DOC18/573067-01
SSD 6471

**SSD 6471 – SYDNEY MODERN – ART GALLERY OF NSW– RESPONSE TO SUBMISSIONS
(RtS) REPORT ADDENDUM**

I am writing to you in reply to your invitation to the Environment Protection Authority (EPA) to comment on the RtS report Addendum (the Addendum) concerning the above project.

Fig 8.0A – Proposed location of intake and discharge points

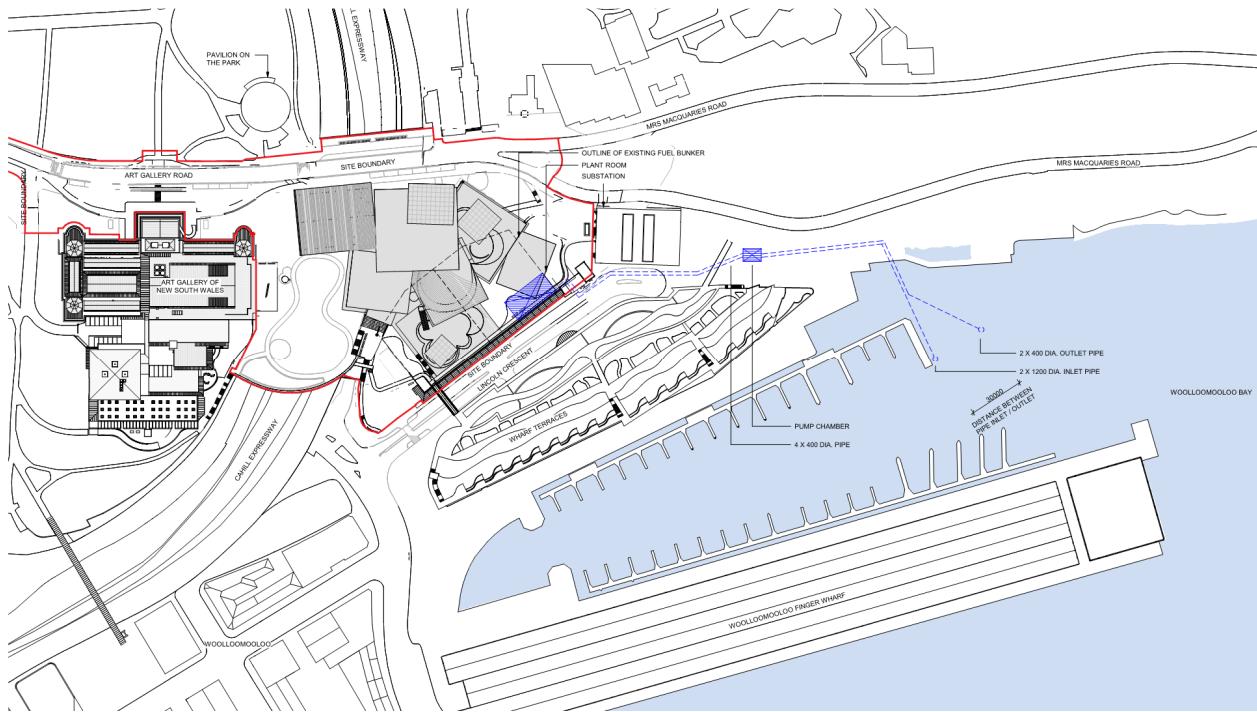
Addendum appendix E confirms that the Seawater Heat Exchange intake pipework is to be cleaned using a conventional pigging system as per industry standard. The EPA remains unclear how the proponent proposes to dispose of the pigging waste.

4. The proponent be required to design and install an appropriate system for the integrated collection and storage of all waste generated from pigging seawater heat exchange system pipework.

5. The proponent be required to ensure all pigging waste from the seawater heat exchange system is disposed of to sewer or, where such disposal is not approved by Sydney Water Corporation, disposed of at a facility legally able to accept that waste for treatment and proper disposal.
